Huntlee New Town Residential Subdivision Stage 1 (MP 10_0137 MOD 14) – Review of Modification

BCD has reviewed the correspondence from Urban Ethos titled '*Section 4.55(1A) Modification Application – MP-10_0137 (MOD 14) – Huntlee New Town, Branxton*' (dated 26 August 2020), including relevant appendices, annexures and attachments in relation to impacts on biodiversity and flooding.

Date: 17/09/2020

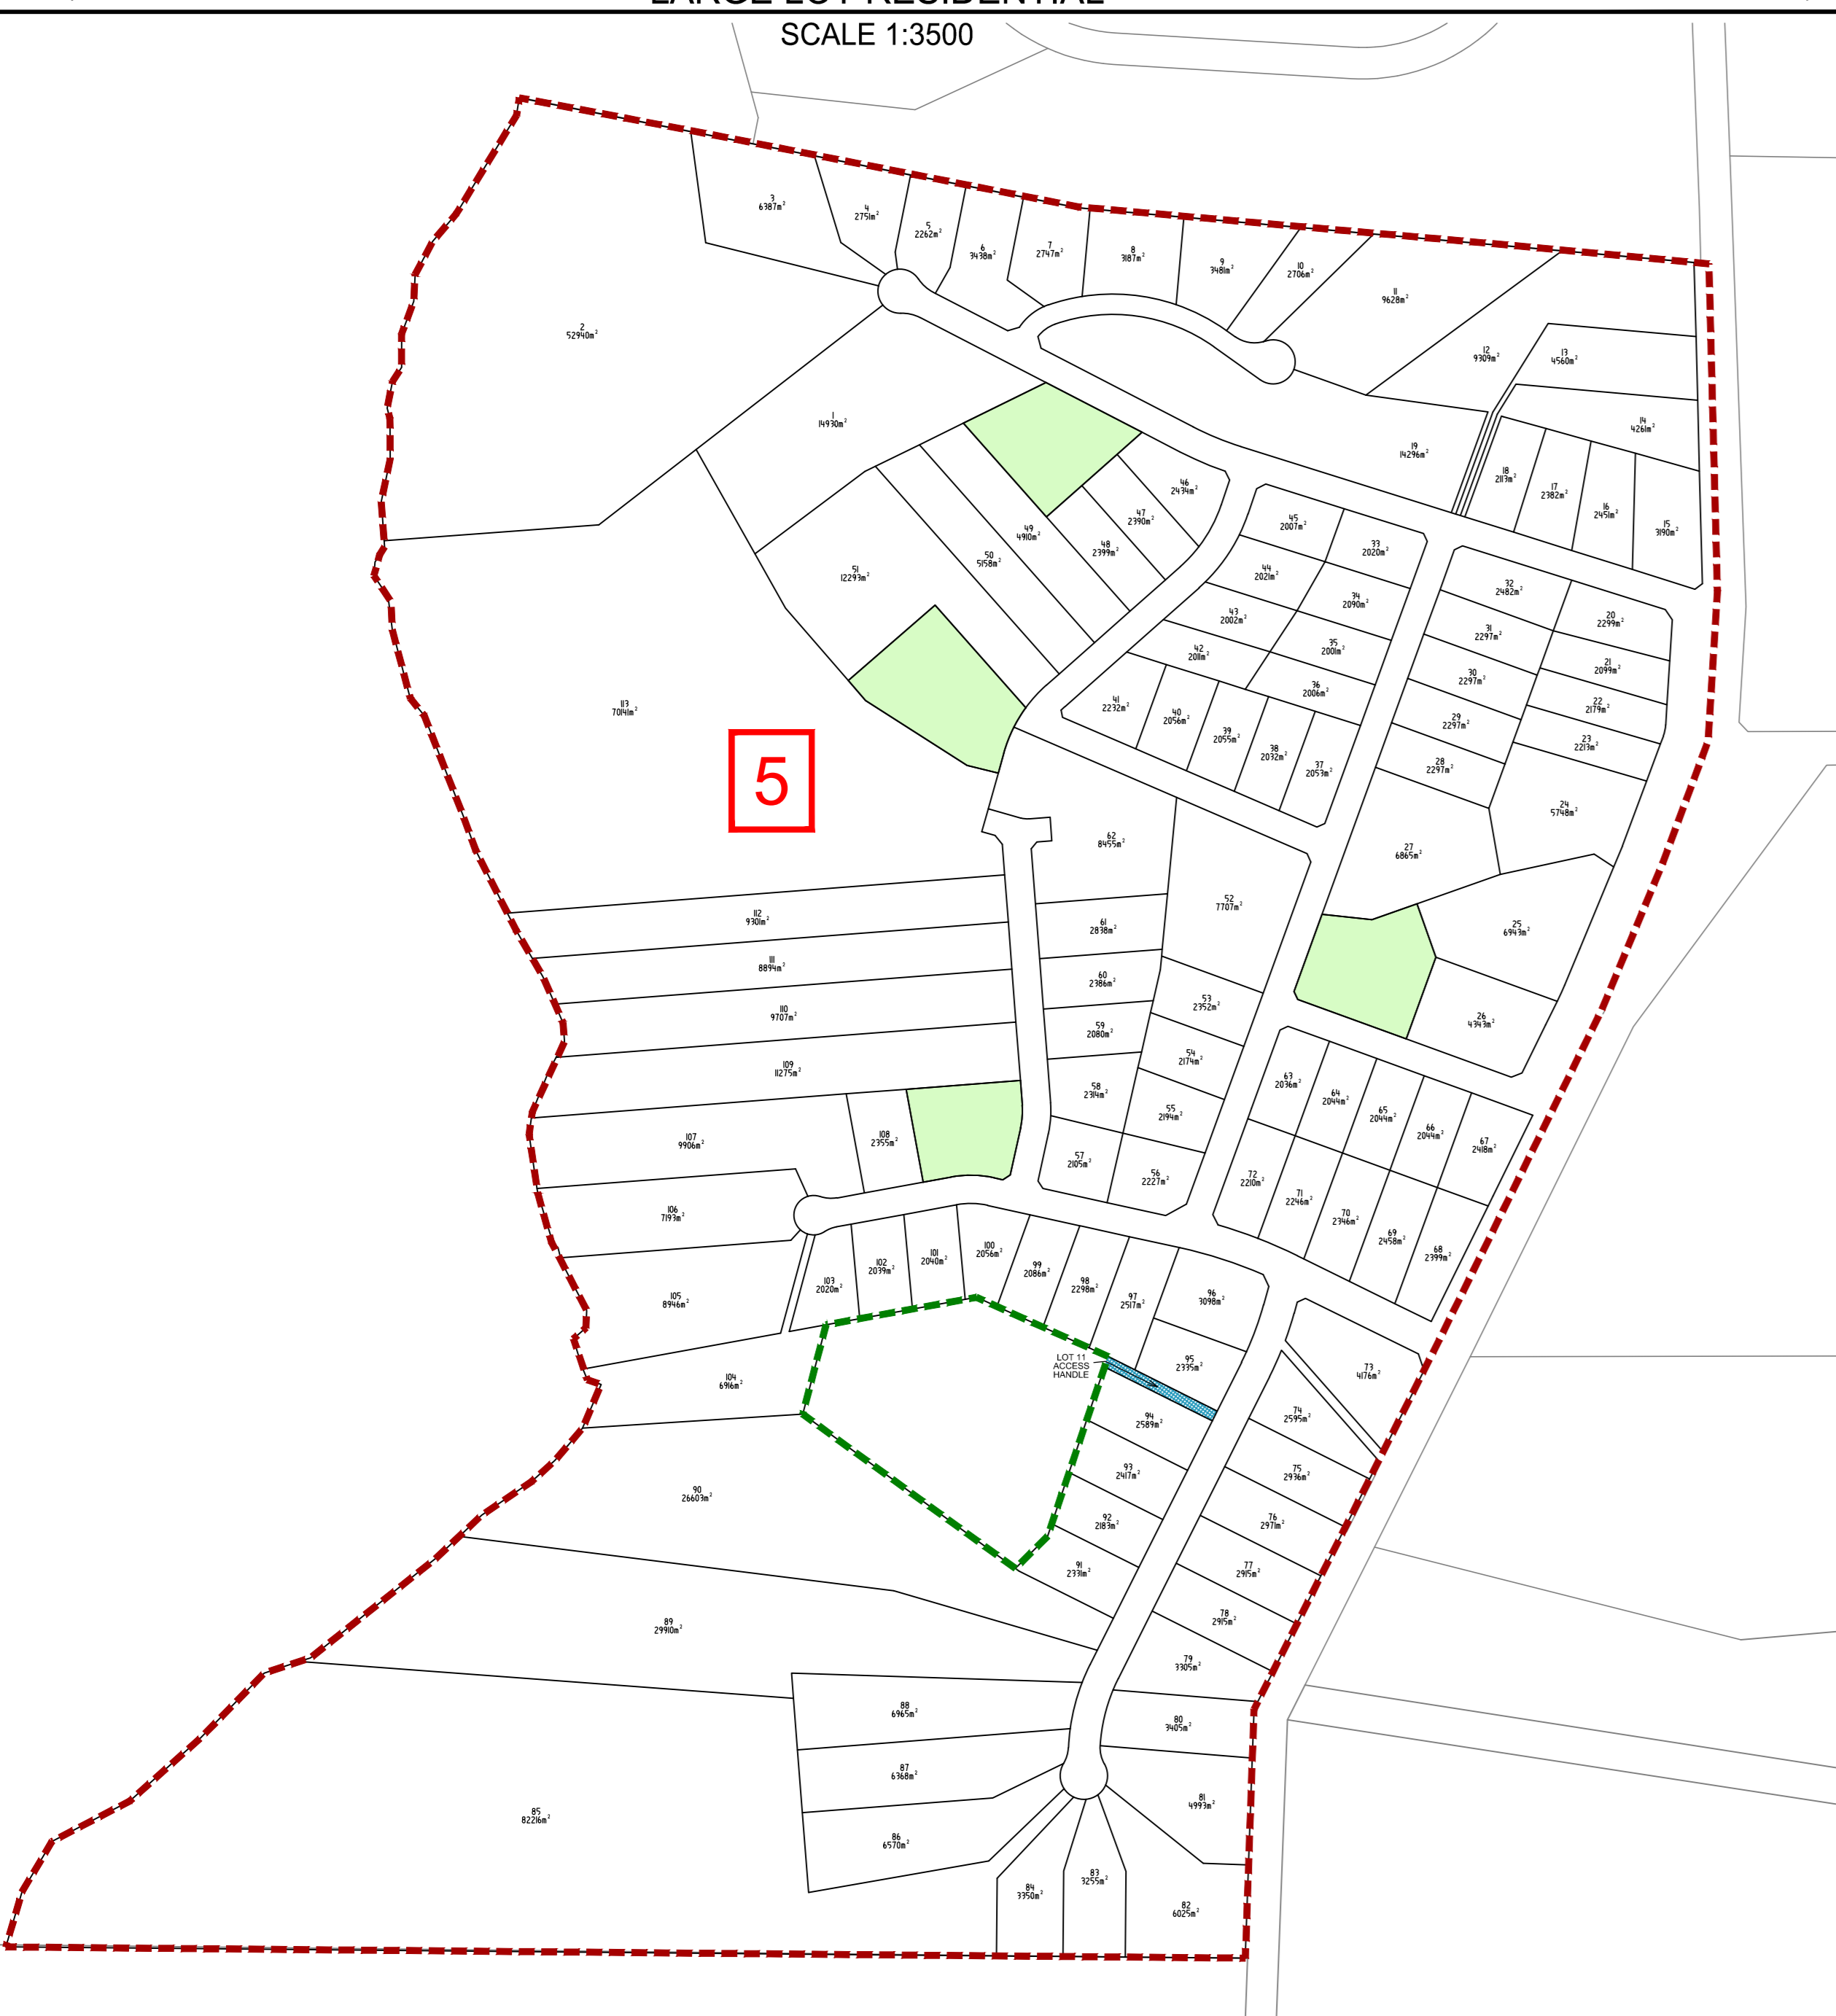
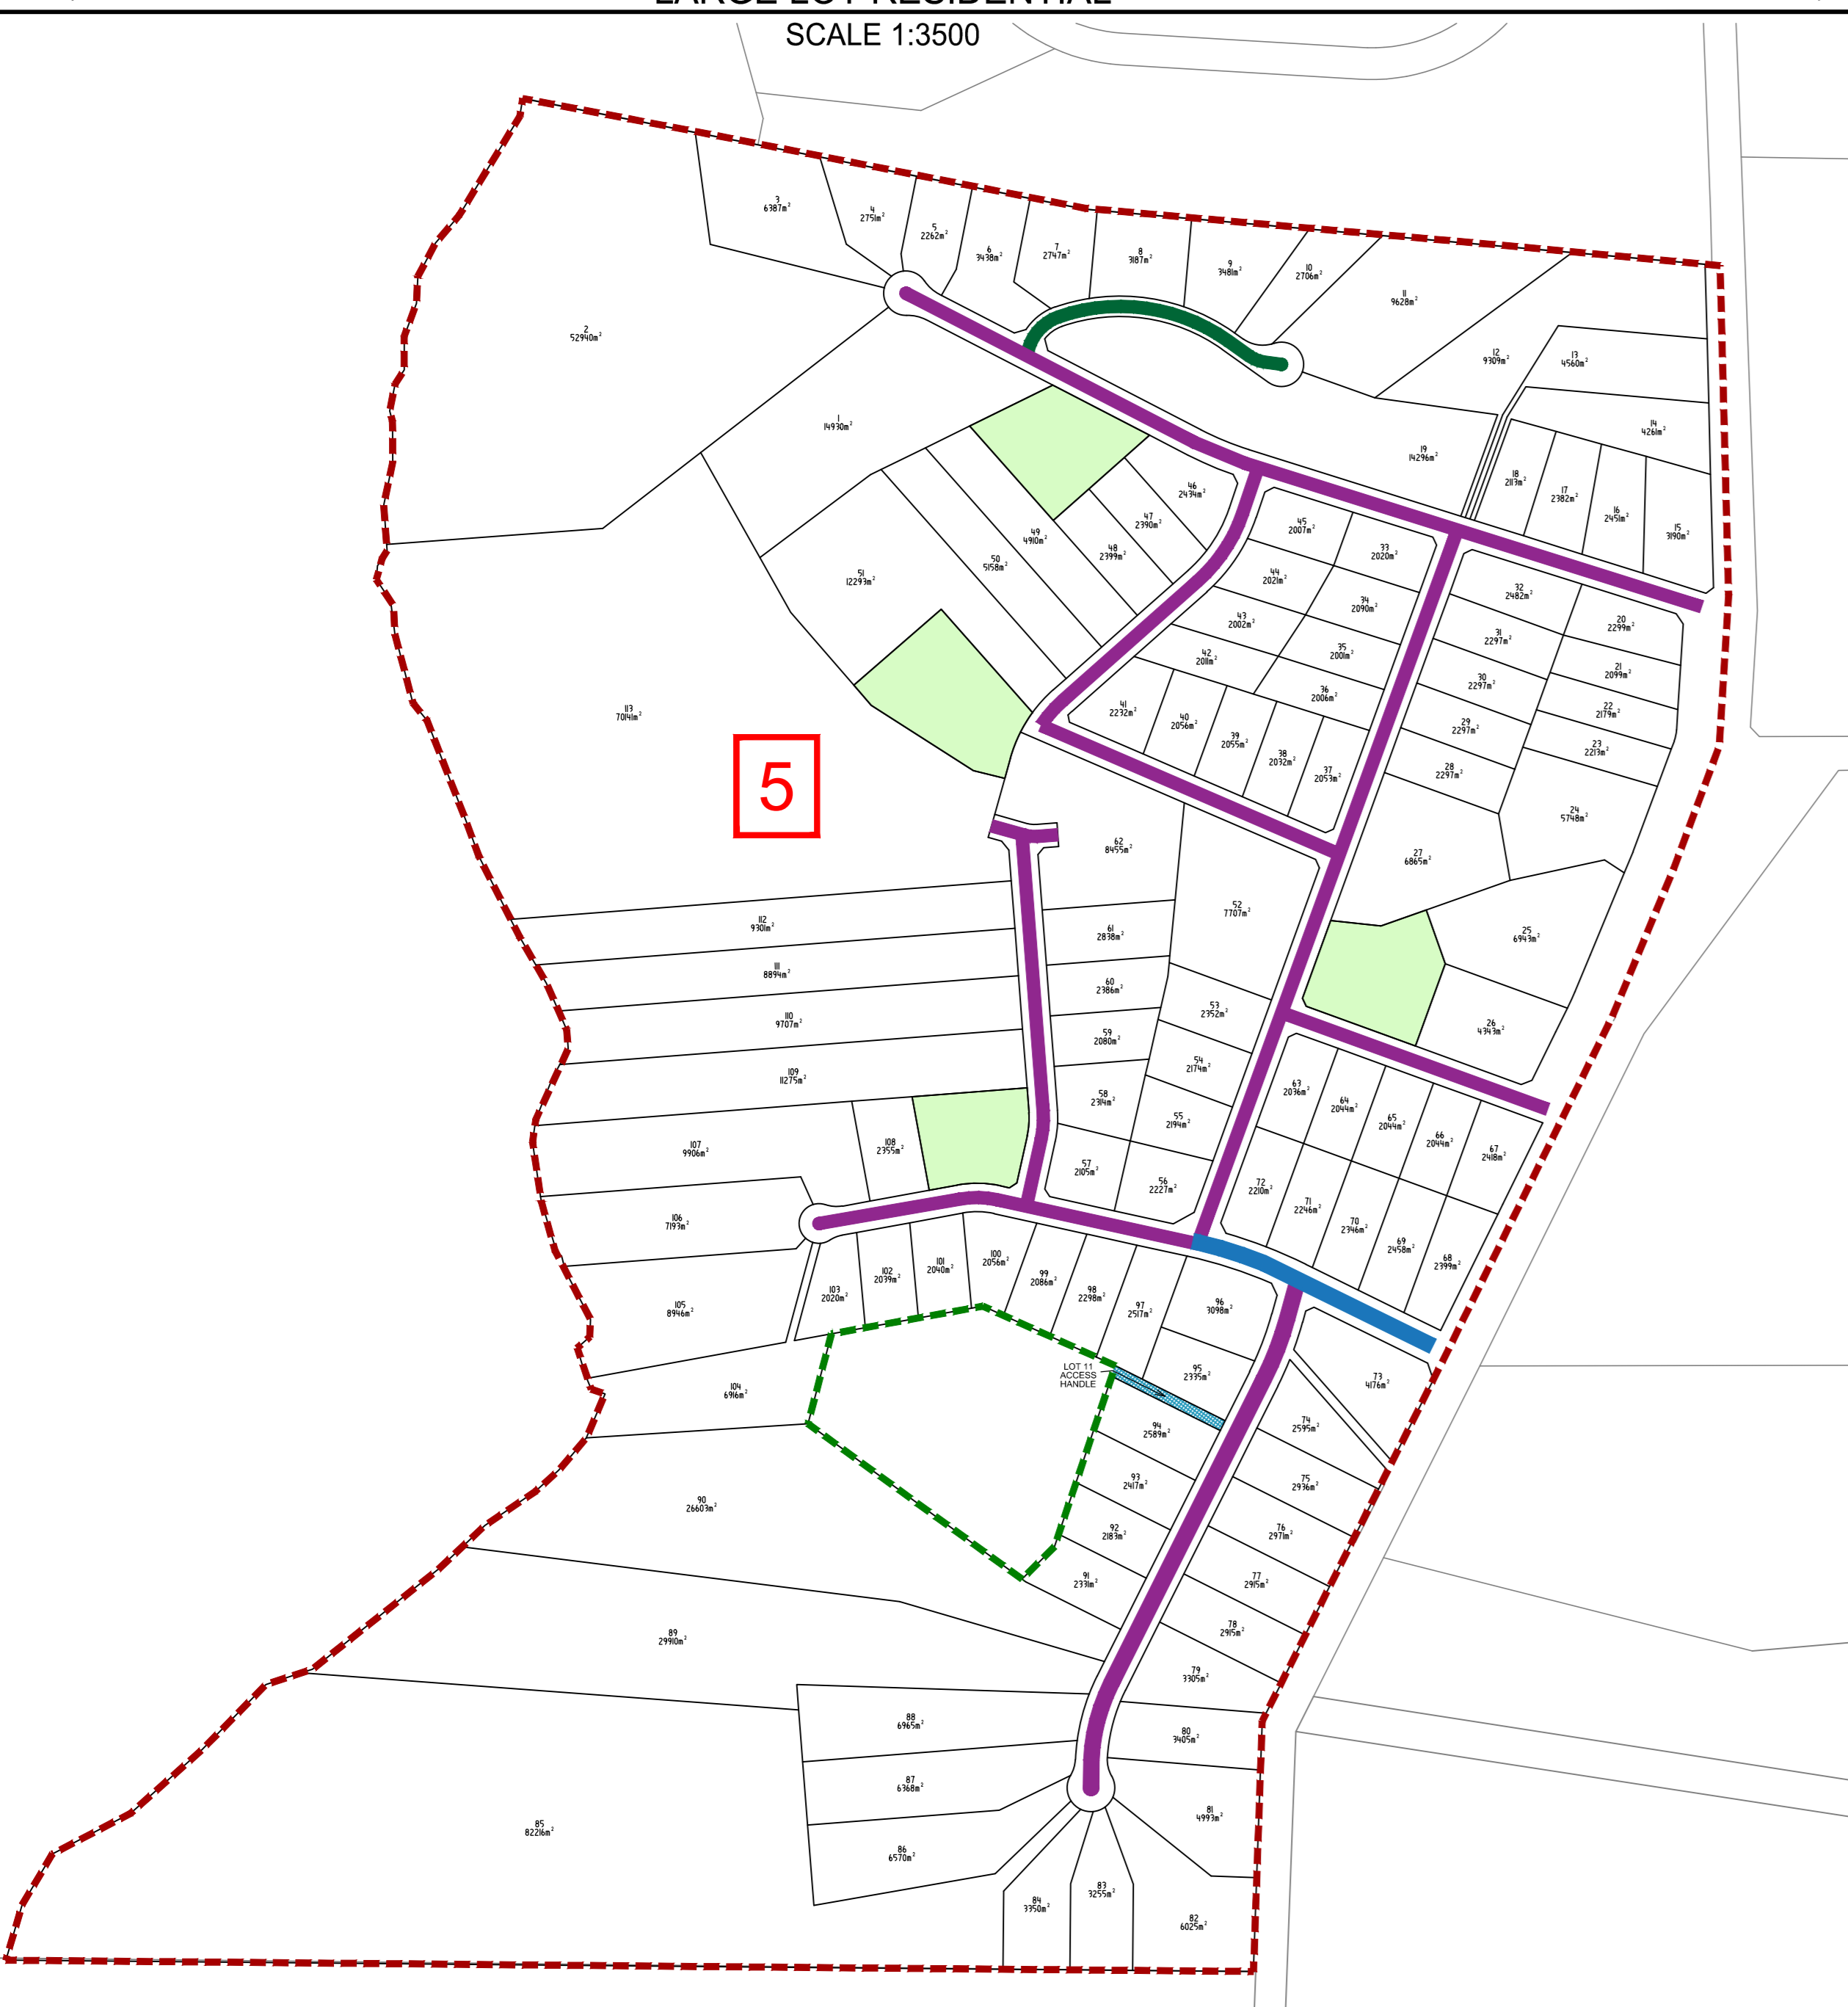
BCD understands that the modification relates to changes to the layout of Residential Substage 5 within Stage 1. Part of the proposed modification proposes the removal of 27.57 hectares of open space, which includes 15.03 hectares of riparian corridor, 11.4 hectares of public open space and 1.14 hectares of local park (as per Table 2 in the Urban Ethos letter, dated 26 August 2020). However, the figures provided do not show the exact location of the areas of open space proposed to be removed.

The condition and nature of the proposed open space areas to be removed is uncertain with respect to native vegetation cover, biodiversity values and potential threatened species habitat. Based on Figure 1 in the Urban Ethos letter, and comparing it to Figure 2, there appears to be significant reduction in riparian corridors, many of these representing 'Core Riparian Zones' on the Huntlee Development Control Plan 2013. When comparing these figures to current aerial photography (such as Near Map), many of these areas represent what appears to be areas of native vegetation, including what would be considered important areas of connectivity and potential areas of threatened species habitat.

BCD recommends that the proponent provides a detailed description of all the proposed areas of open space to be removed. This should describe (but not be limited to): (i) the extent of native vegetation present, including derived native grasslands where present, (ii) the appropriate Plant Community Type, including if it represents a threatened ecological community, (iii) the habitat value, (iv) any potential candidate threatened species that it may support, (v) its size and (vi) the condition of the vegetation. All areas are to be shown on a georeferenced aerial image.

Figure 2 – Hydrograph of peak from 1% AEP 36-hour event

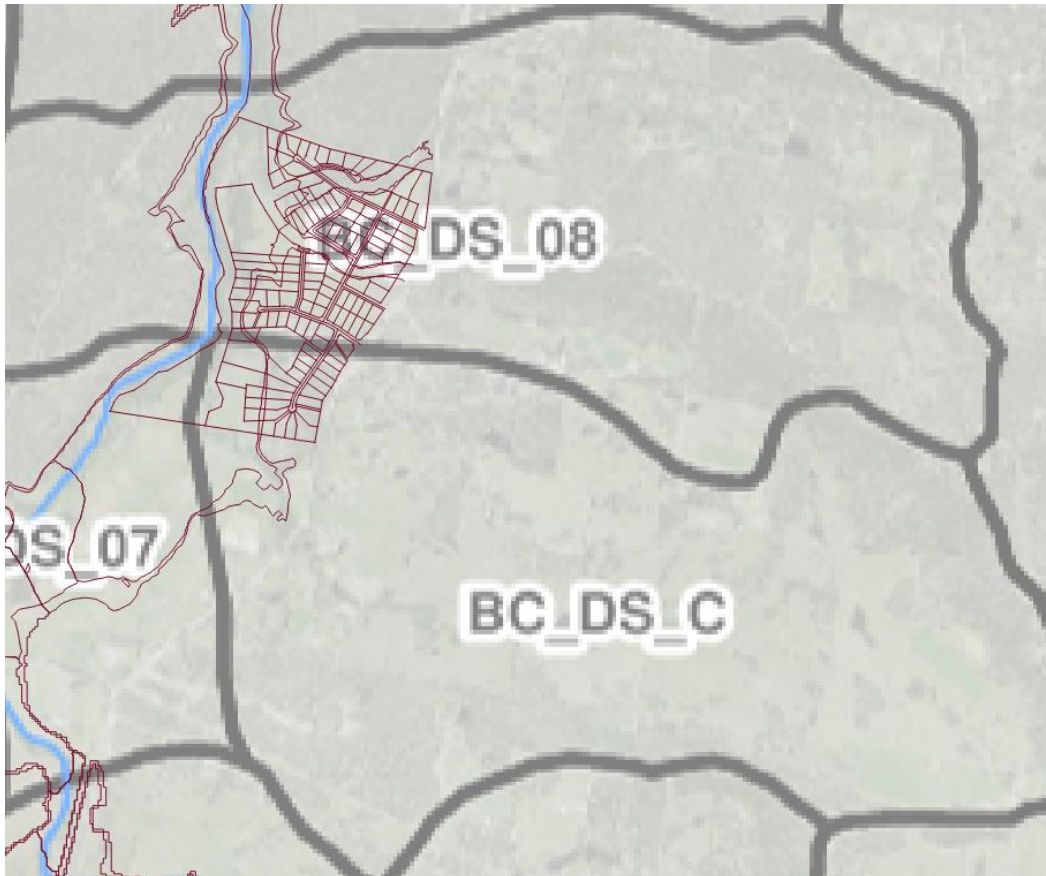
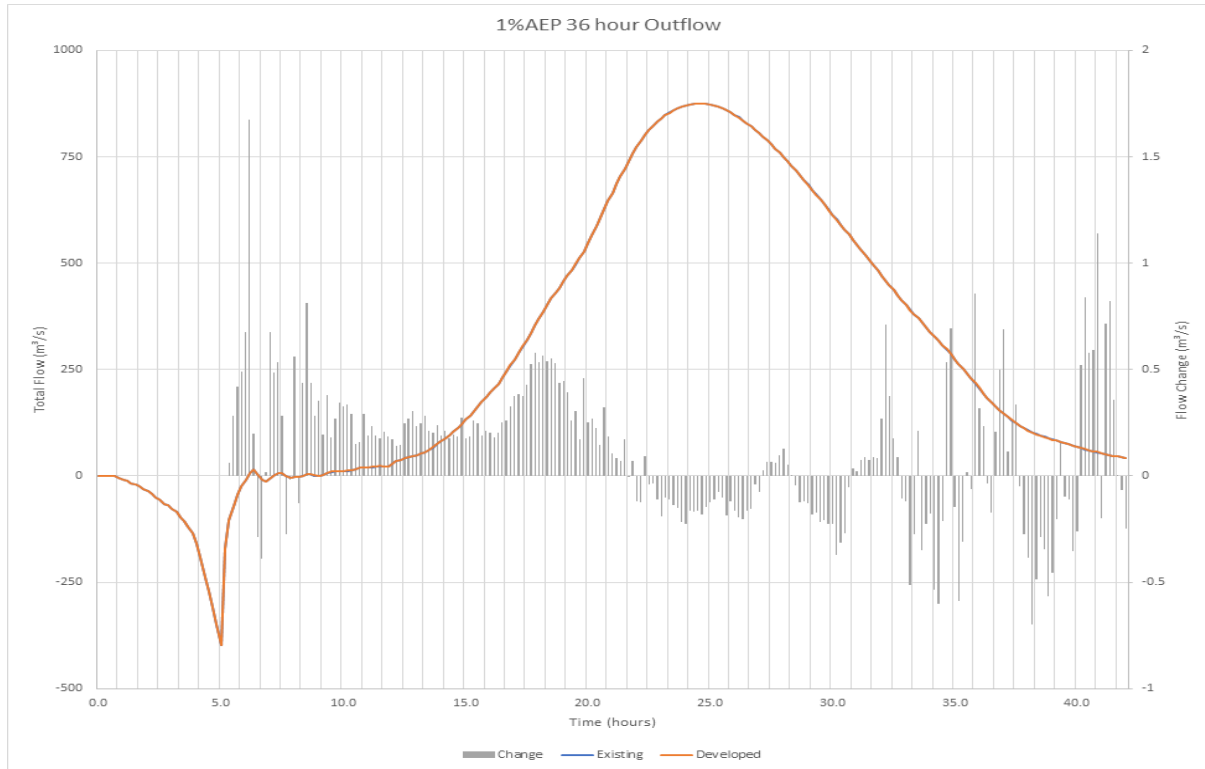
The MOD 14 flooding assessment provides an analysis of relative timing of flood flows from the developed area against the extended catchment as justification to remove on-site stormwater detention that was previously required. This approach uses local area modelling that assumes there is no concurrent flooding in Black Creek. Concurrent flooding occurred during storm events in 2007 and 2015 and therefore the broader Black Creek flood model should be used to determine if on-site detention can be removed without increasing flood risks or flood impacts.

The proponent should revise flood modelling using the broader Black Creek flood model to determine if on-site detention can be removed from the proposal without causing additional flood impacts.
